LORSON RANCH EAST FILING NO. 2

FINAL PLAT
LORSON RANCH EAST
FILING NO. 2
JOB NO. 70-065
DATE PREPARED: 07/03/2018
DATE REVISED:

SHEET 2 OF 8

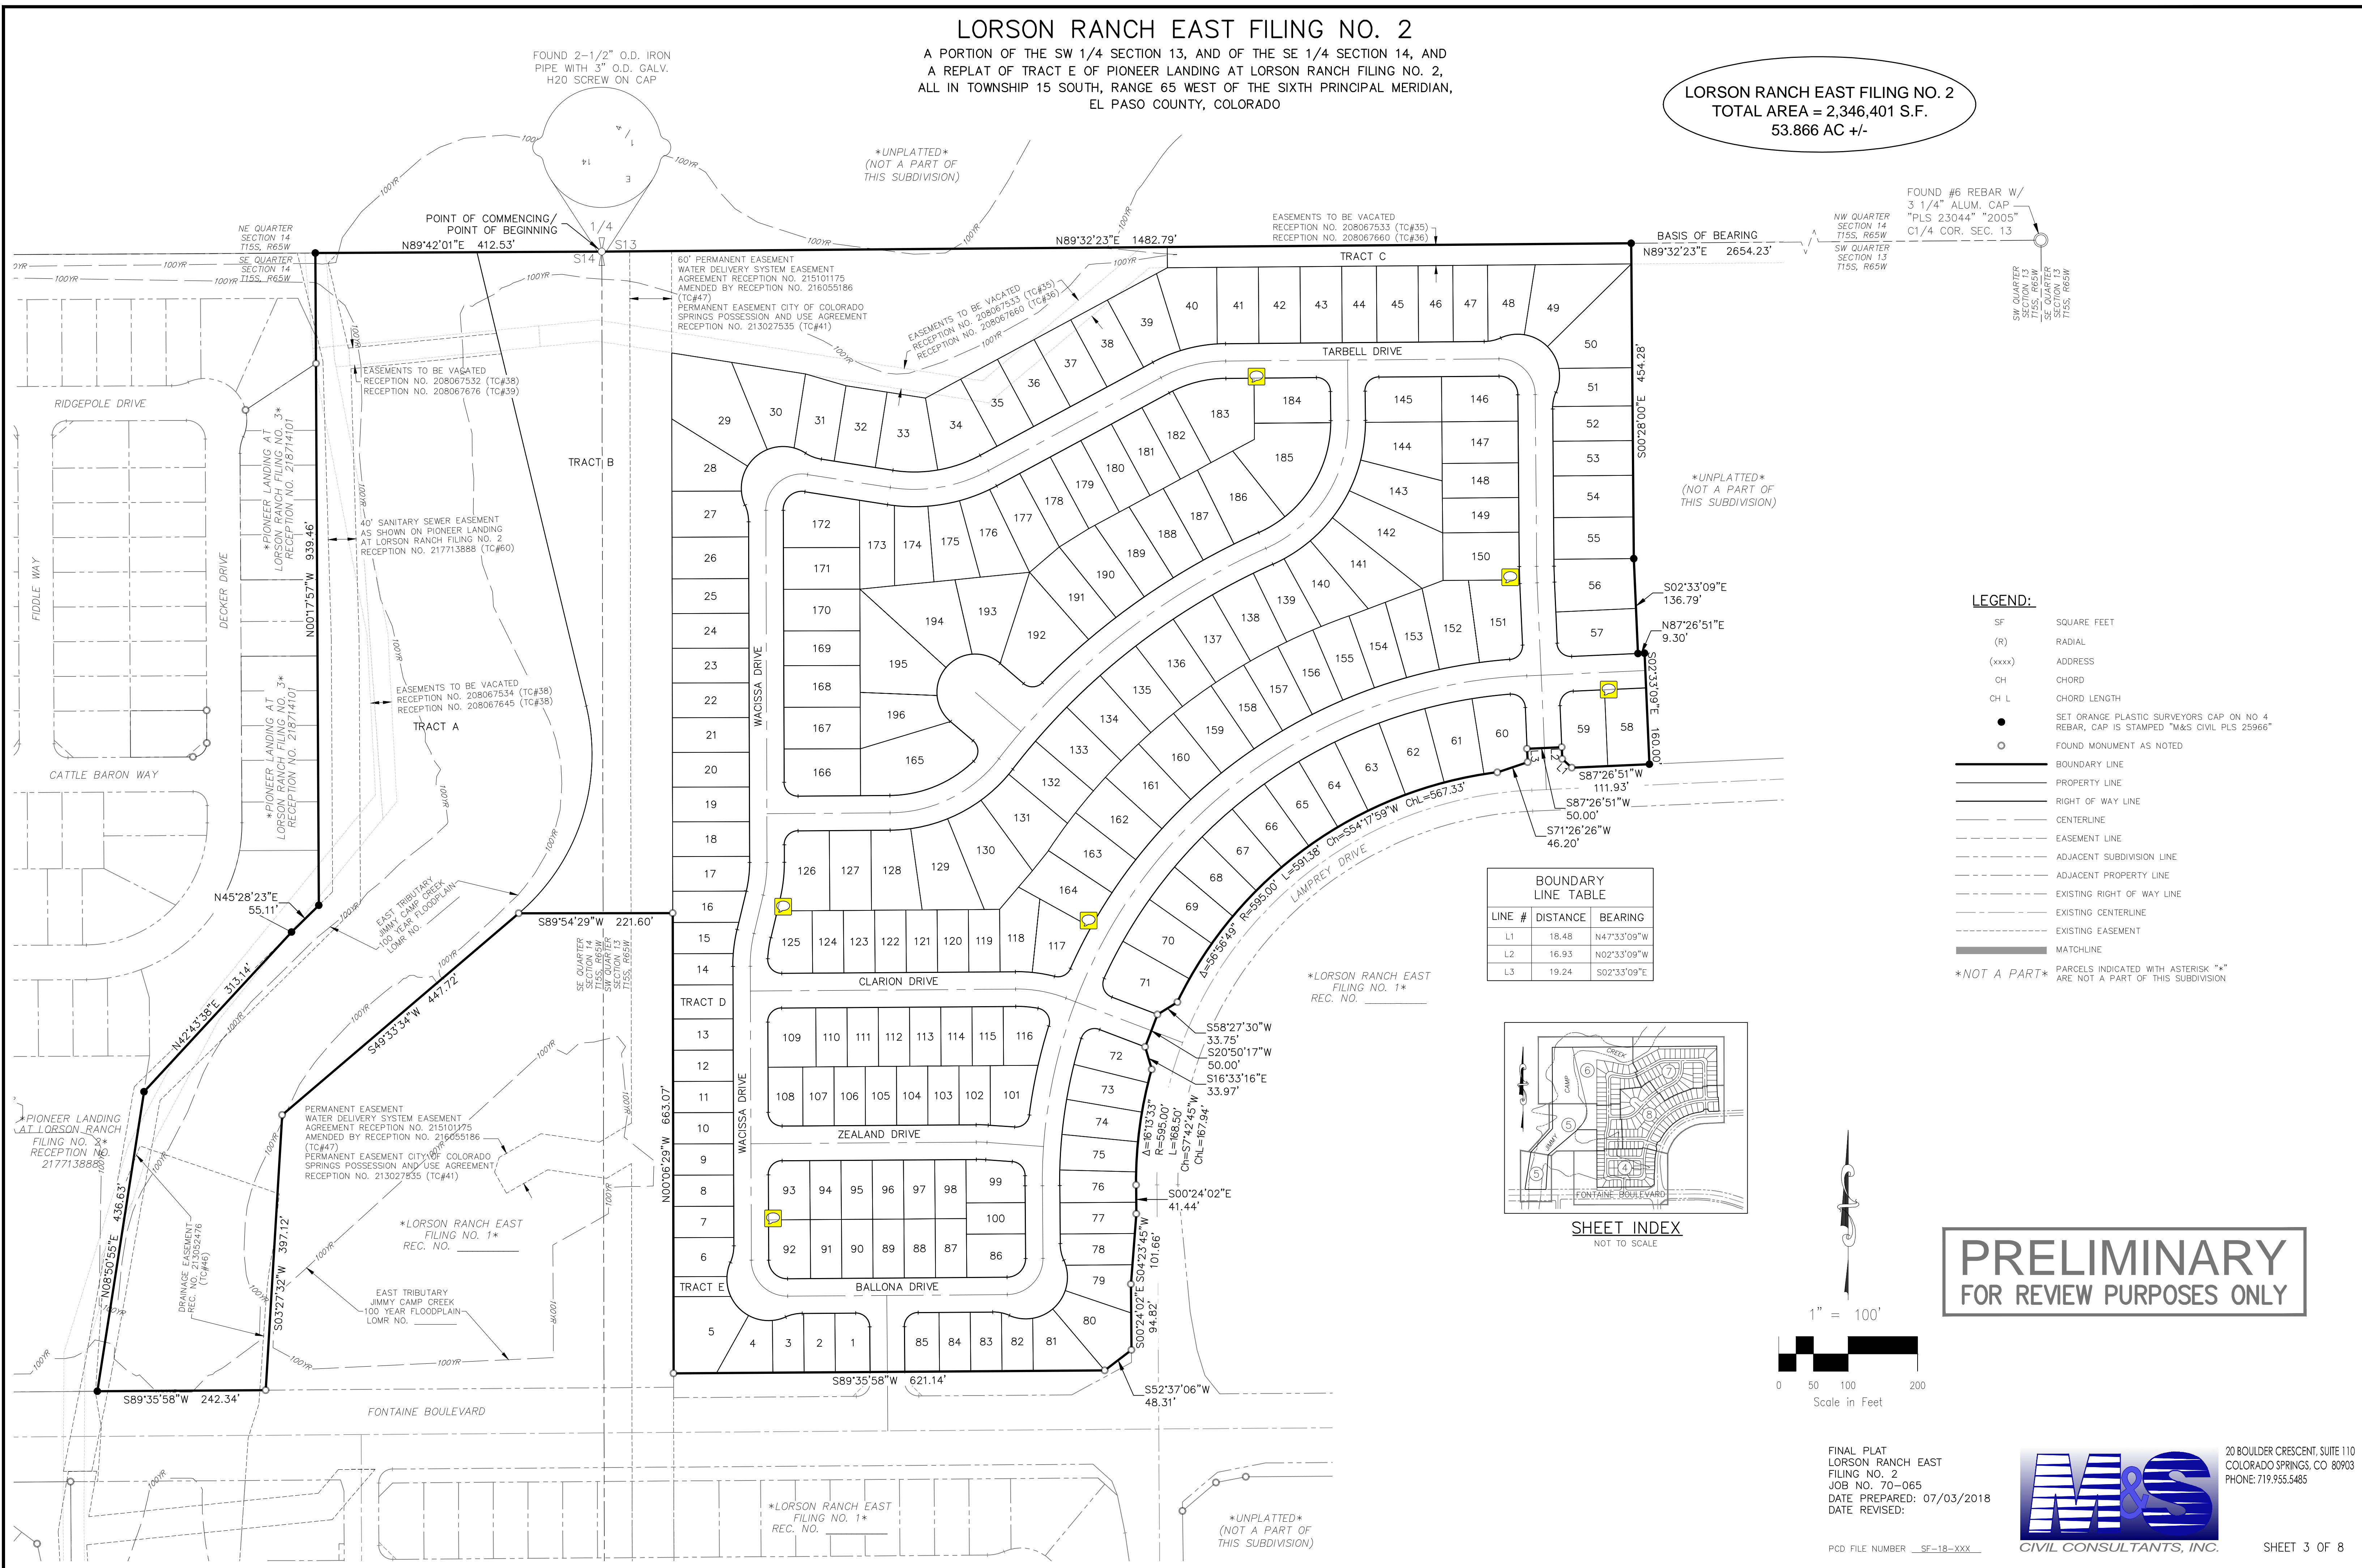
Please use a varying line type for the plat boundary on all sheets. It is very difficult to delineate what is in this plat and what is not.

Thicken
Subdivision
boundary line

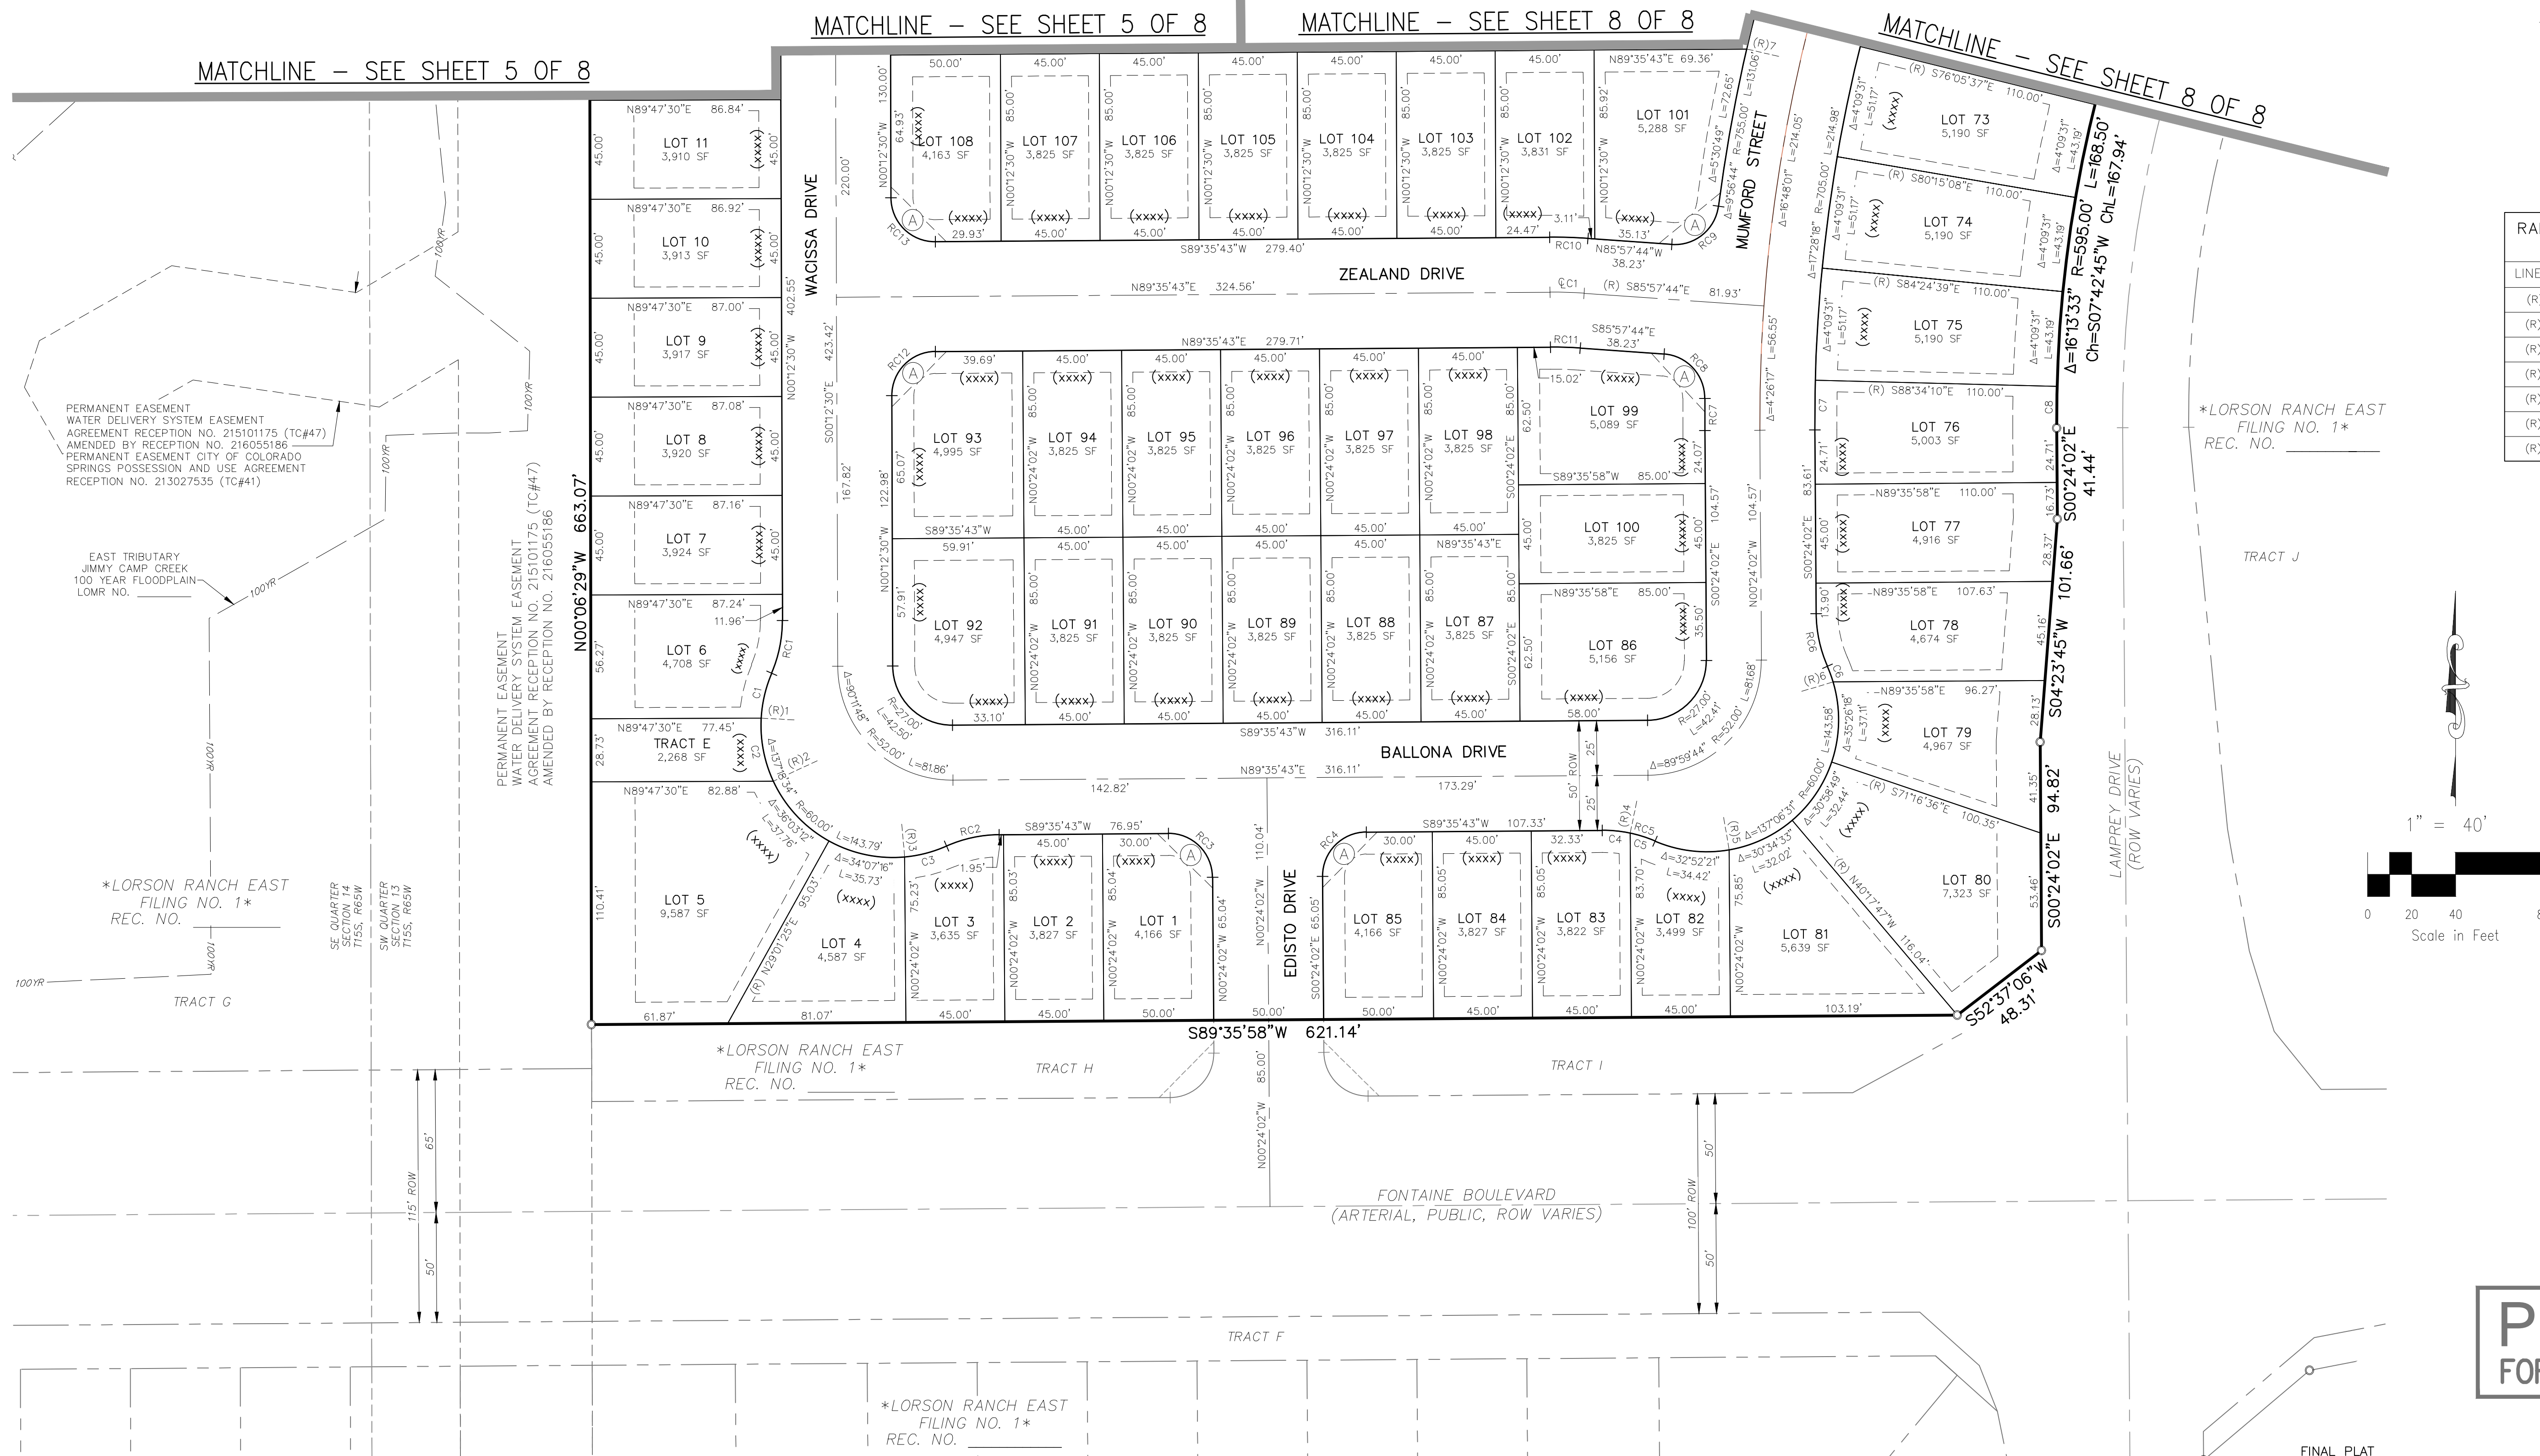
Is this the area that the SDS easement is in? Add leaders to clarify. The line type is different than the key map.
